Application no: **3/2022/0488**

Address: **88 Fairfield Drive Clitheroe BB7 2PS**

Proposal: **Side Extension and fence to the side.**

Proposed Plans

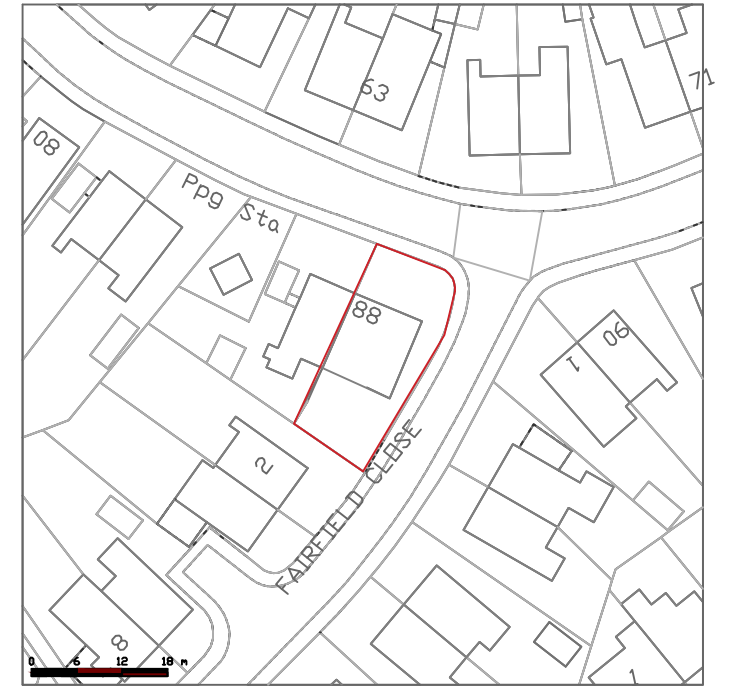
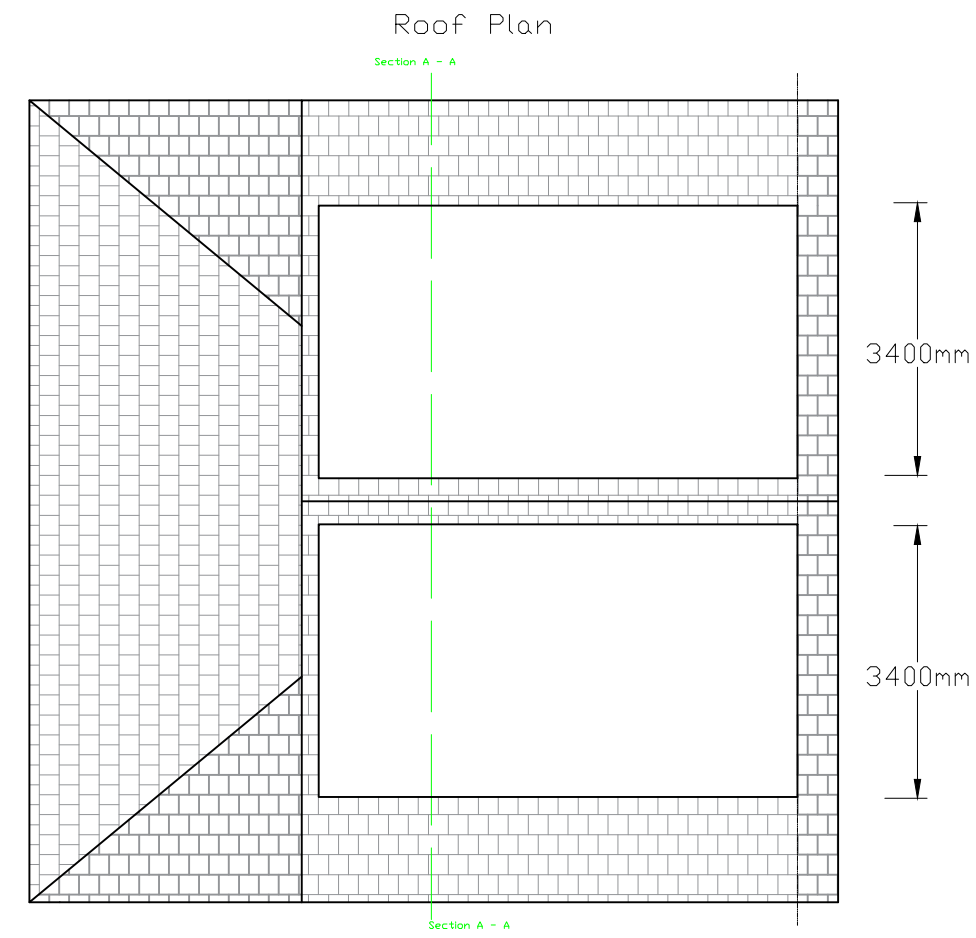
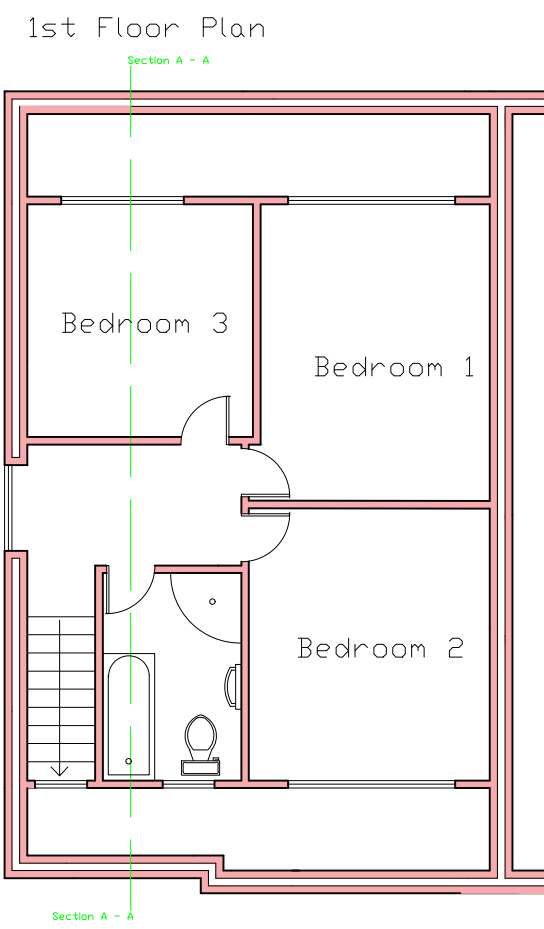
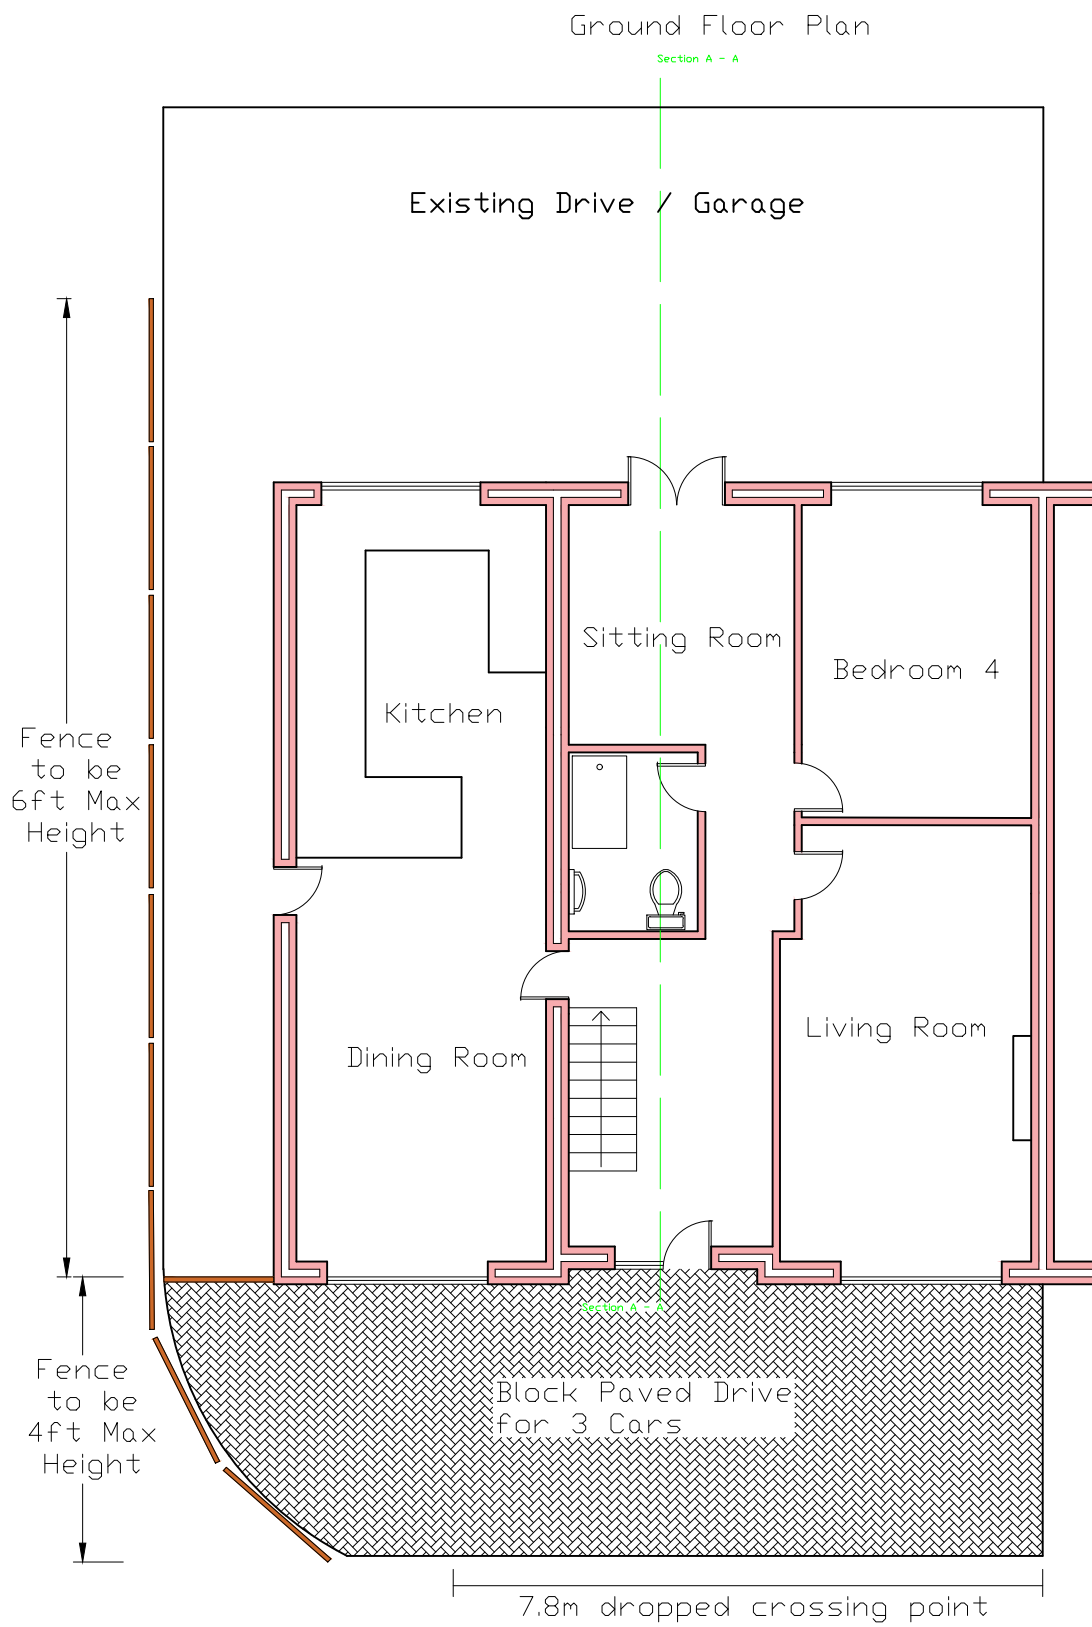
The LHA have reviewed the supporting documents and while the LHA have no objection to the side extension, the LHA require a revised plan showing that the fence which is located to the side of the driveway which provides 3 parking spaces for the dwelling is reduced in height to a maximum of 0.9m, when the fence is located in the site's visibility splays. The LHA require these amendments to be made to ensure that the occupants using the driveway can clearly view the road ahead without any obstructions.

The LHA also require the height of the fence to be reduced when the fence is located within the junction's visibility splays between Fairfield Drive and Fairfield Close. This is because the dwelling is located adjacent to the junction and so any obstructions within the junction's visibility splays should comply with the LHAs maximum height guidance.

Furthermore, the LHA require further information regarding the existing garage which is accessed from Fairfield Close. The LHA require information as to whether the garage will remain as existing and should the garage remain, the fences which are located to the left of the access should be reduced in height to 0.9m, due to them being located within the access's visibility splays.

These amendments should be shown on a revised plan submitted to the LHA and should the height of the fences be reduced in height as stated in the comments, the LHA will have no objection to the proposal.
